**From:** Sharon Craig  
**Sent:** 21 August 2019 12:56  
**To:** planning  
**Subject:** FW: Application 3/2019/0091 Greendale View, Chatburn - Amended site plan

**Application 3/2019/0091**  
**Greendale View, Chatburn**

**Subject:** Application 3/2019/0091 Greendale View, Chatburn - Amended site plan

SITE PLAN

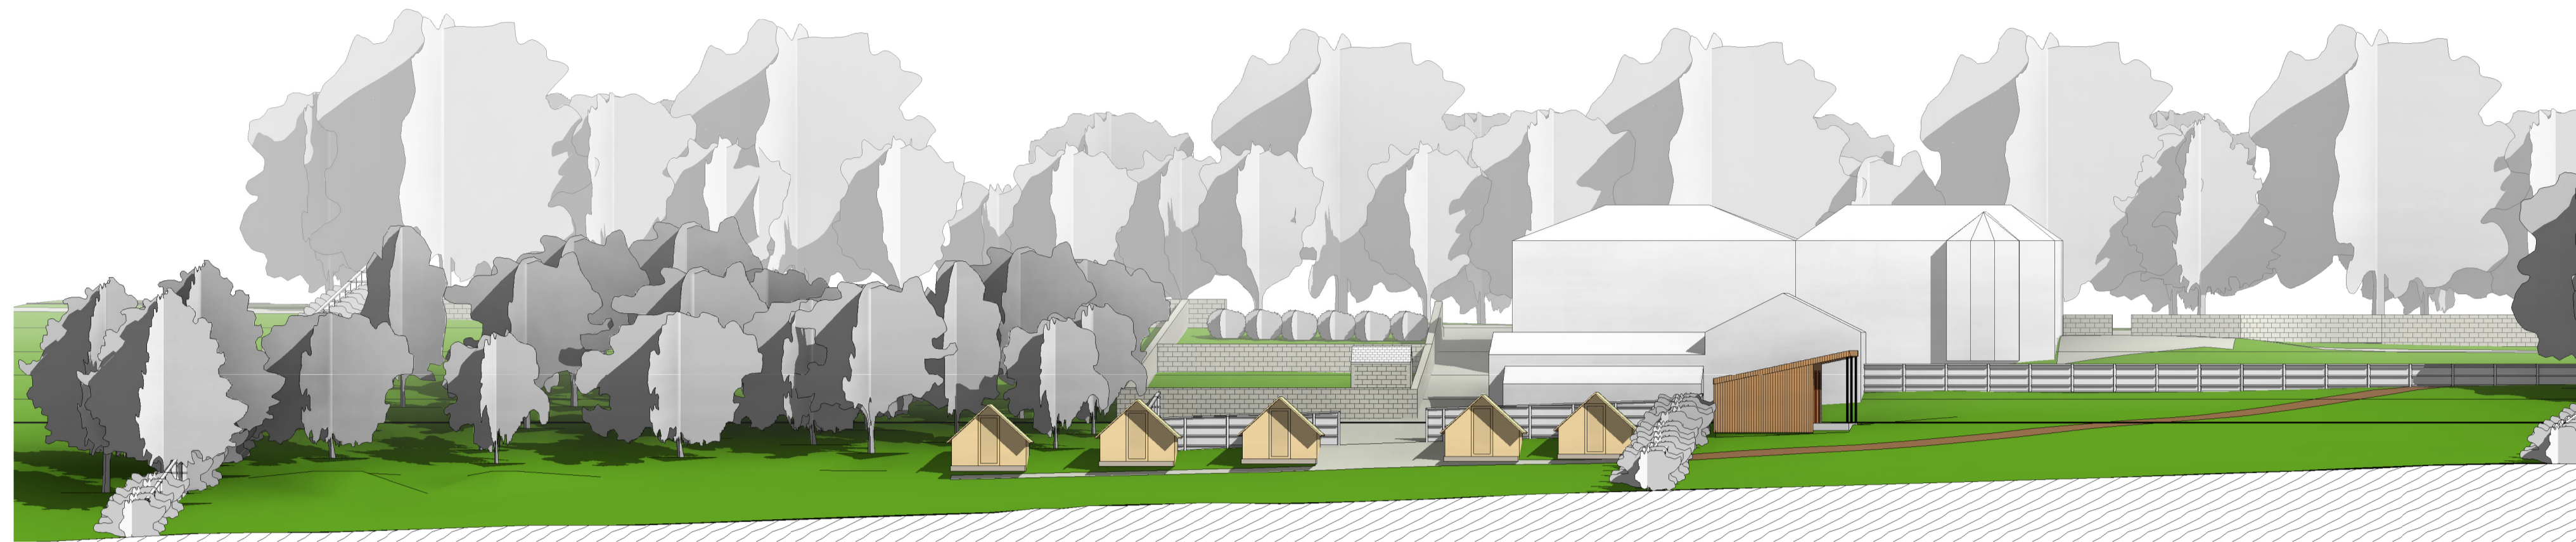
The revised pedestrian route is more convoluted but it would offer a greater proportion of better quality surfacing than the original proposal which would be more conducive to transporting luggage etc to and from the pods. On the assumption that the applicant has access rights to the rear of the café and 2 residential properties I would have no adverse comments to make

I have received the attached revised plan which includes a less direct pedestrian access from the car park to the log cabins. Is this a concern?

The Countryside Officer was advised by your client that the 'low impact permeable footpath' (revised plans received 8/8/19) is now to run adjacent to the building complex rather than diagonally through the garden area. Please confirm any revisions in this respect.

In its latest comment, LCC Highways consider the revised plan's reference to 'Proposed 2.5m bridleway' to be "an information item rather than an element of the application". I would be grateful for your comment on this assumption.

I can confirm that the annotation and reference to the 'Proposed 2.5m bridleway' was placed upon the drawings for information purposes only, I believe that this matter is being dealt with via another application.

The footpath location will be updated and with you shortly.

Further to your previous email in regards to the ingress and egress of the access to the previously proposed parking area, our client has agreed to put in place gated access along with signage to mitigate the possibility of this area being used by the guests.
